A/44/26/PL – April 2025 infiltration testing and BRE 365 compliance

DRAINAGE (SHEET 1)

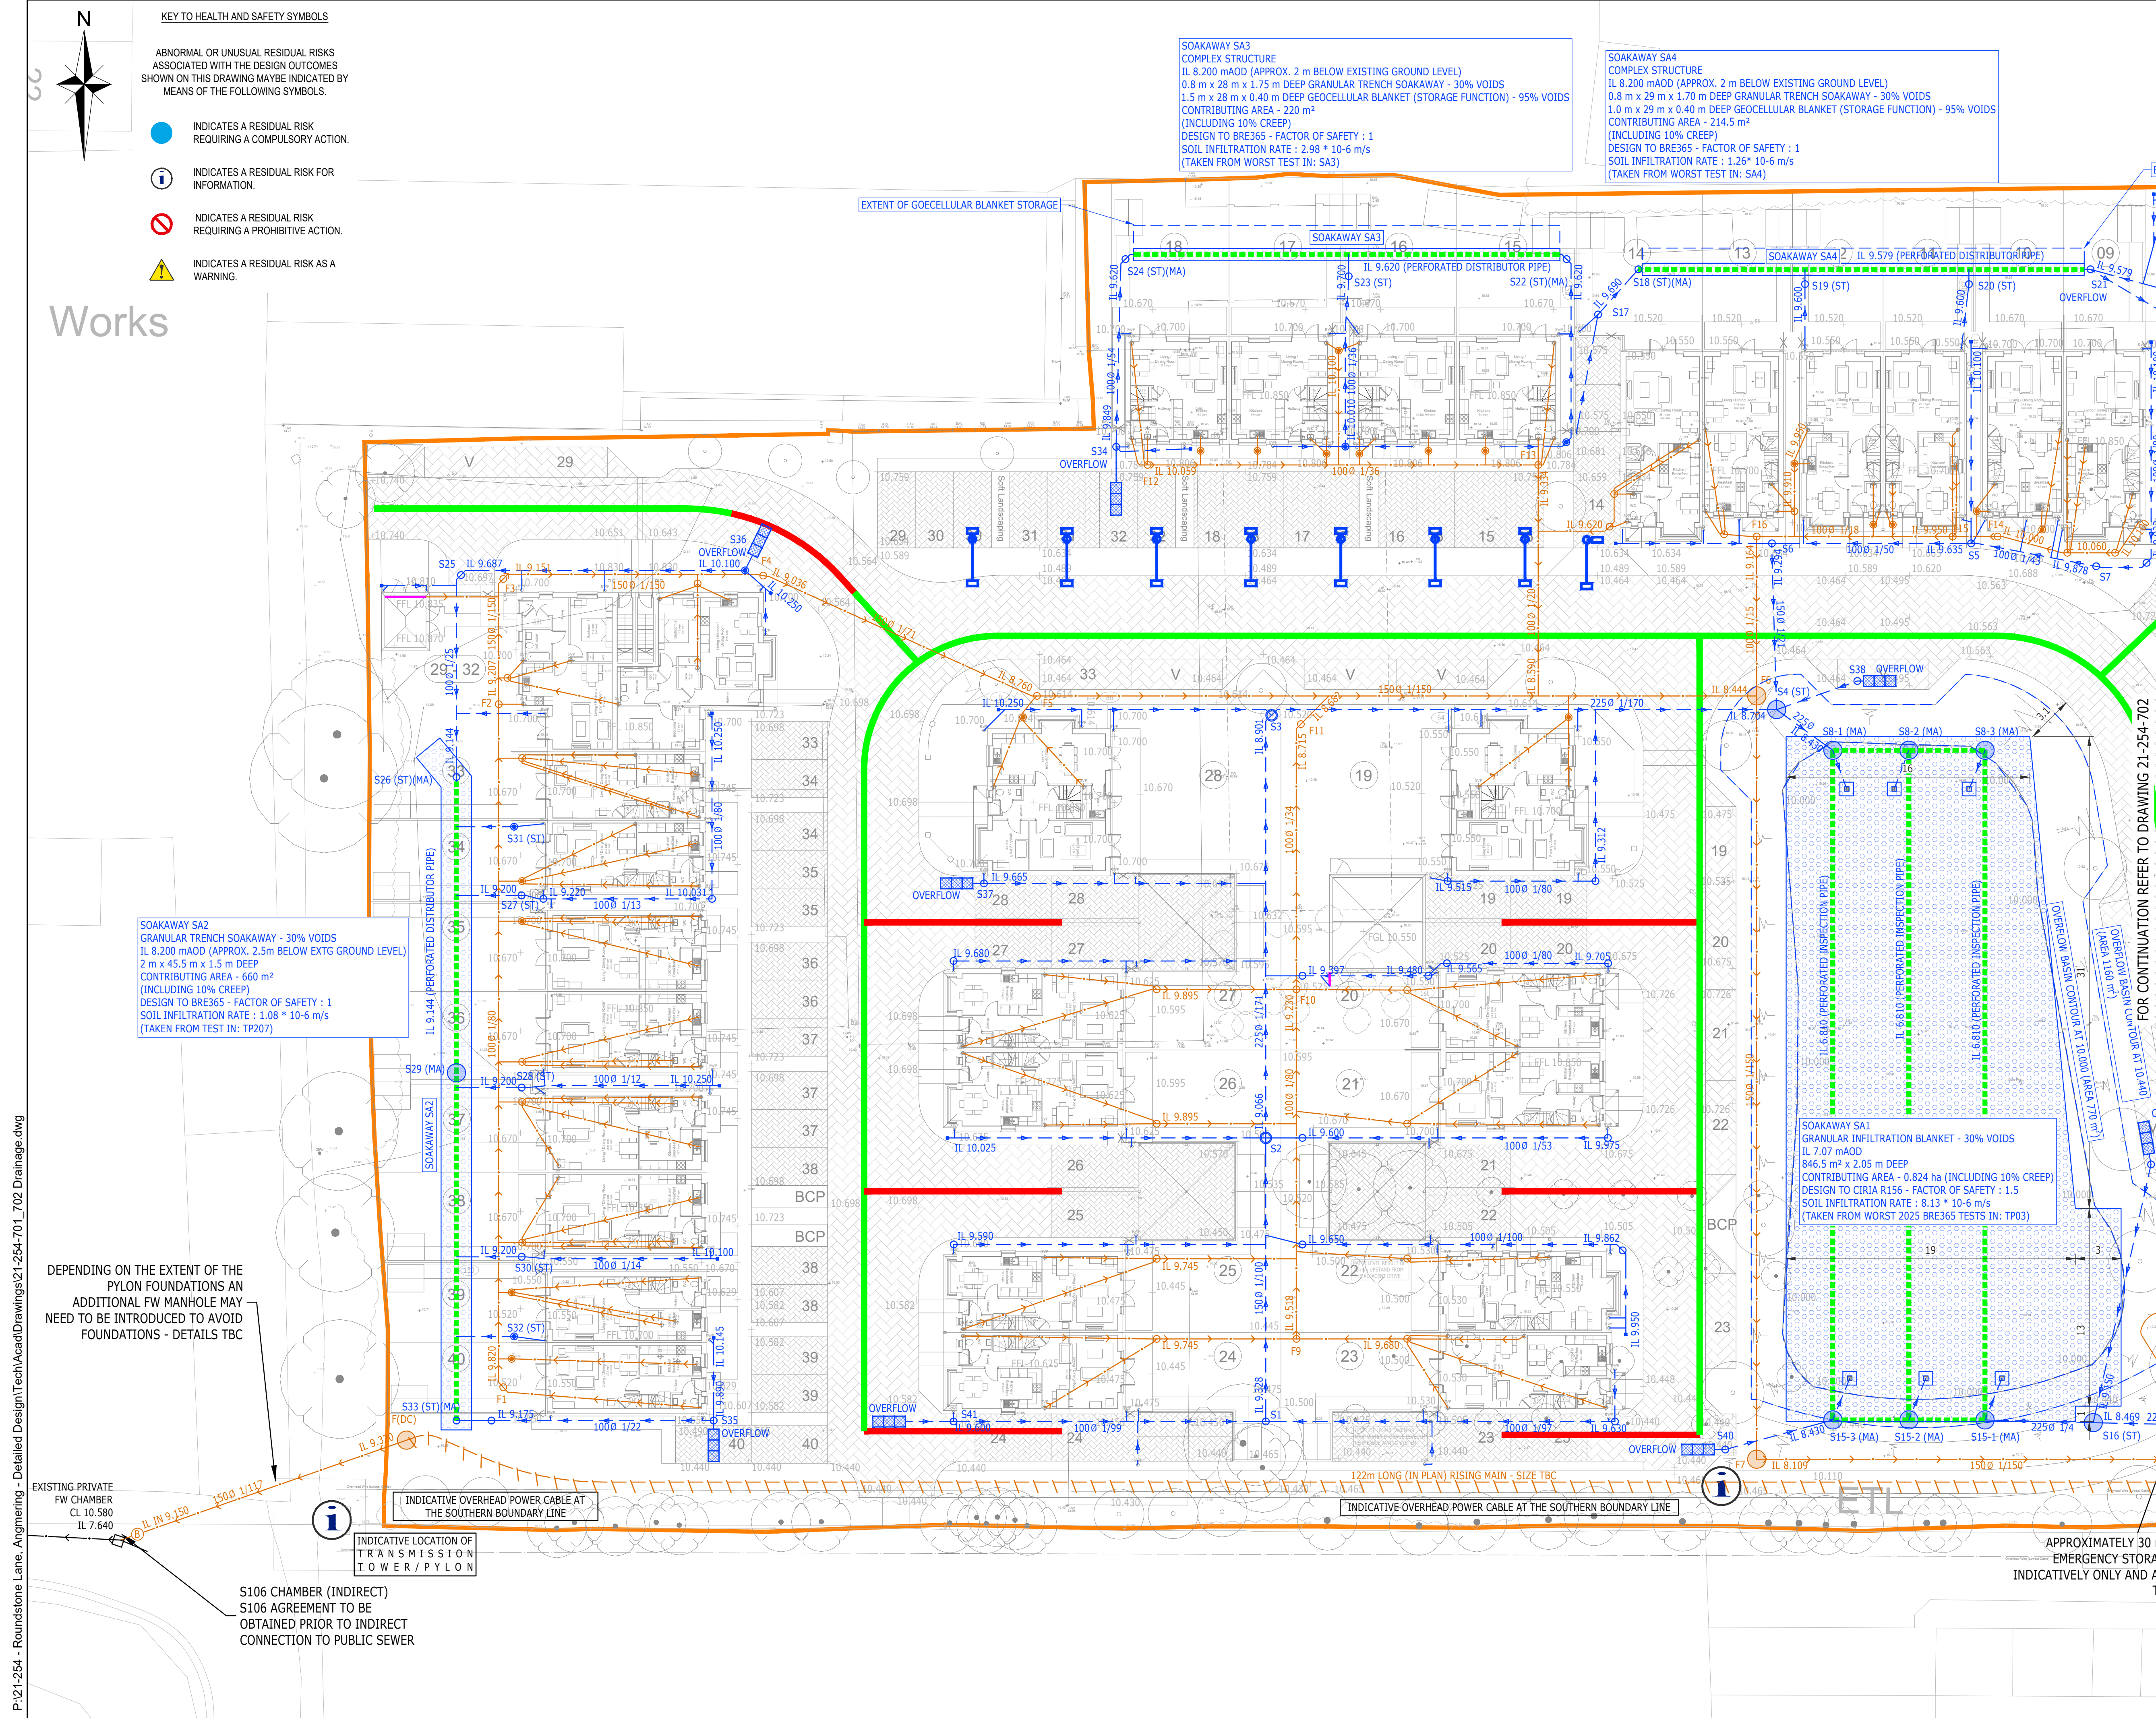
The engineer has confirmed that the filling undertaken on 22 April 2025 could not constitute the third successive filling of tests commenced twelve days earlier on 10 April 2025. At most, it could be treated as a separate additional infiltration test. Consequently, the design infiltration rate of 8.13×10^{-6} m/s was not derived from a completed BRE 365-compliant three-fill sequence and should not be relied upon, without qualification, as the sole basis of the drainage design.

No winter infiltration testing has subsequently been undertaken. Instead, the drainage design submitted with the current application continues to rely upon the April 2025 testing, notwithstanding that the controlling design rate was obtained from a purported third successive fill undertaken twelve days after the first two.

The issue is therefore not merely whether the figure of 8.13×10^{-6} m/s is numerically conservative. It is whether that figure was derived through a valid and recognised testing sequence capable of establishing a reliable design infiltration rate. The independent advice confirms that it was not derived from a completed BRE 365-compliant sequence.

We must therefore ask again: what new evidence, technical analysis or change in applicable guidance has led ADC now to regard the April 2025 testing—previously described as “flawed” and having “failed”—as acceptable, and to permit the resulting infiltration rate to be relied upon as the controlling design parameter for a drainage system whose ultimate discharge is wholly dependent upon SA1, thereby making it a single point of failure for the entire site?
